From: Sarah Burrow <Sarah.Burrow@arun.gov.uk>
Sent: 14 June 2022 13:16
To: Planning.Responses <Planning.Responses@arun.gov.uk>
Cc: Amber Willard <Amber.Willard@arun.gov.uk>
Subject: RE: Planning Consultation on: AL/39/22/OUT

Engineers Comments Regarding Surface Water Drainage

Application No: AL/39/22/OUT
Registered: 20th April 2022
Site Address: Land to South of Dukes Road Fontwell Arundel BN18 0SP
Grid Reference: 494824 107404
Description of Works: Outline application with some matters reserved (appearance, landscape and scale) for the erection 9 No. residential dwellings.

Figure 6.2 – EA Surface Water Flood Map

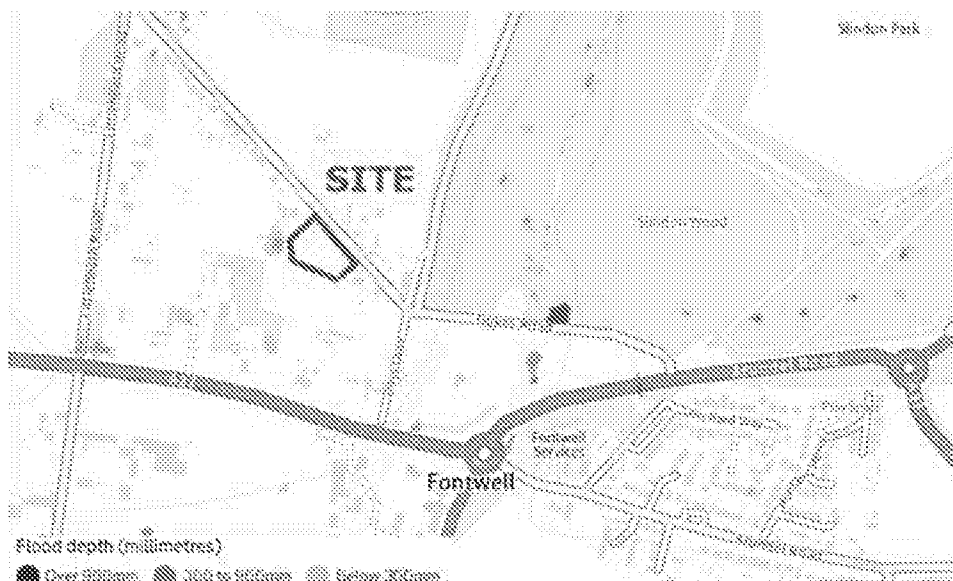
The planning officer should be aware that there is an area in the south western corner of the site which is susceptible to surface water flooding. There should be no alterations to the levels of the site in this area as this could increase flood risk on neighbouring property.
